Our ref: NE/2022/135016/01-L01
Your ref: 6/2022/2300/COND
Date: 7 November 2022

Former Volkswagen Van Centre, Comet Way, Hatfield, AL10 9TF

Submission of details pursuant to condition numbers - 1 (construction management plan), 5 (surface water strategy), 6 (surface water scheme), 7 (drainage), 8 (foundation), 9 (design plan), 10 (accessible housing scheme), 11 (highway improvement), 12 (samples), 13 (hard landscaping), 14 (soft landscaping), 15 (hard landscaping - roof garden), 16 (external lighting), 17 (cycle store), 18 (cycle store under-croft/open air), 19 (balcony screens), 20 (energy & sustainability statement), 21 (pv cells plan), 22 (bat & bird boxes), 23 (noise compliance), 24 (noise compliance), 26 - (suds), 27 (access), 28 (ev charging points), 29 (parking), 30 (bin stores), 31 (roof gardens), on planning permission 6/2020/3222/MAJ.

Figure 2: Site Overlay of Borehole Locations

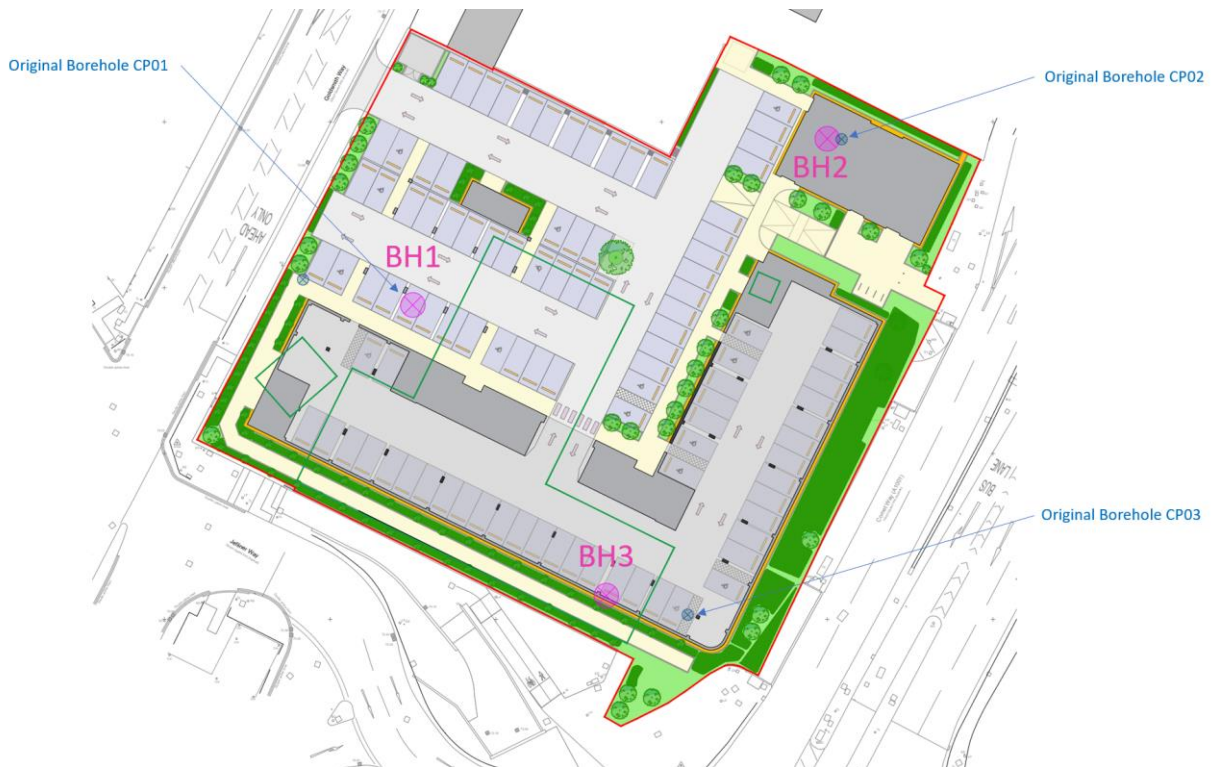
There are two exploratory holes logs that provide information about the geology encountered at the anticipated depths of the proposed CFA piles: CP01 and CP02. Both indicate the piles will terminate at or close to the interface between a clay aquitard, which separates the upper and lower gravel aquifers, and the top of the lower gravels. This interface is likely to vary across the site and so some piles will puncture through the clay aquitard. The lower gravels lie directly on top of the chalk aquifer. Groundwater in the lower gravel aquifer is known to be in hydraulic continuity with the chalk aquifer and bromate and bromide pollution lies within these gravels as well as the Chalk.

Please provide further information on how it will be ensured that the upper and lower gravel aquifers are kept separate throughout piling activities and the life of the development, so that the existing bromate and bromide pollution does not exacerbate.
